Opposing to Epping to Thornleigh Third Track Proposal. Application number SSI 5132.

We object to the Epping to Thornleigh Third Track Proposal and consider that the EIS is inadequate and does not address the full impact of this proposal. It will cause untold damage to the health of residents and to the fabric of the Beecroft Cheltenham Heritage Conservation Area. Do not approve this project, reconsider the alternatives and protect the community.

Figure 5.6 Cross-section and elevation - New Cheltenham Station concourse building
Note: Indicatively added to future design

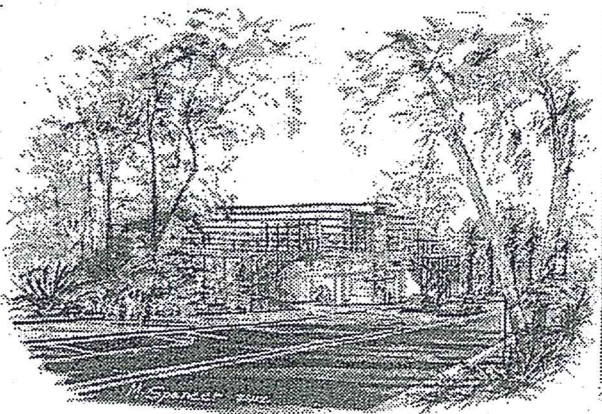
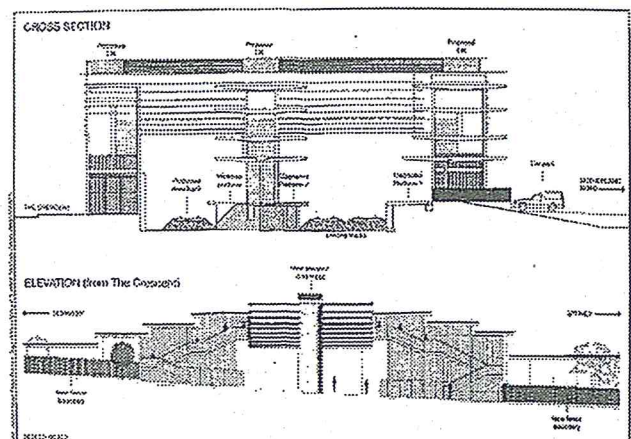
- The proposed redevelopment of Cheltenham Station shows no regard for the HCA. The visual impact of the proposed 13m high glass and steel concourse is totally unacceptable in this HCA.

Concept design drawing of proposed changes to Beecroft Station (Parsons Brinckerhoff 9/3/12). Former side platform shaded in pink.

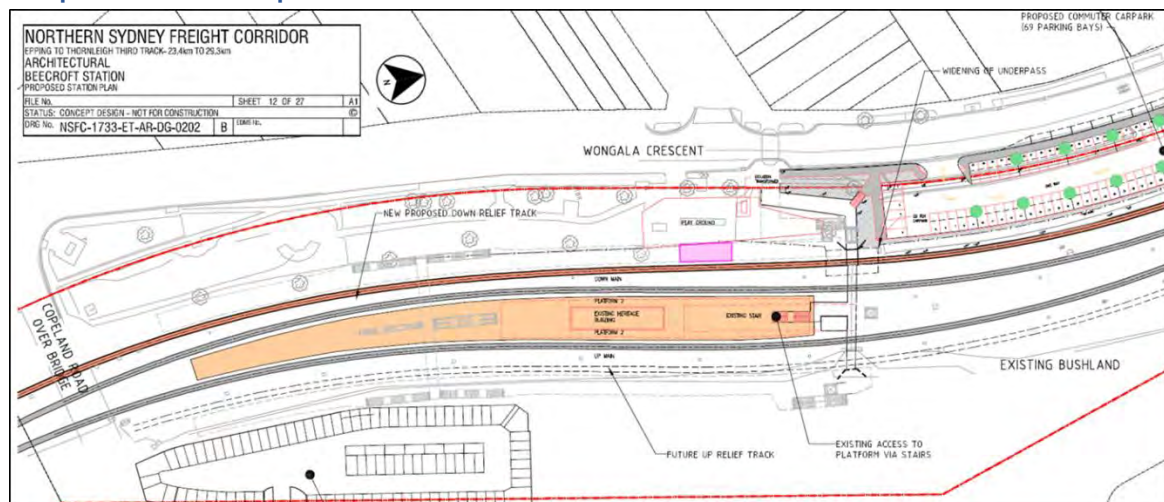
- There has been inadequate assessment of the project's impact on the fabric of the Beecroft Cheltenham Heritage Conservation Area (HCA).
- The plan given for Beecroft Railway station Precinct is vague. The relationship to the trees, playground and original 1895 platform located south of the present station is not shown. A fourth track is shown on the eastern side. The plan does not include urgently needed lifts to allow disabled access at Beecroft Station.

- Beecroft Station Gardens have a heritage listing with Hornsby Council but the impact on them has not been adequately addressed. No arborist's report is given for the trees which will be removed.
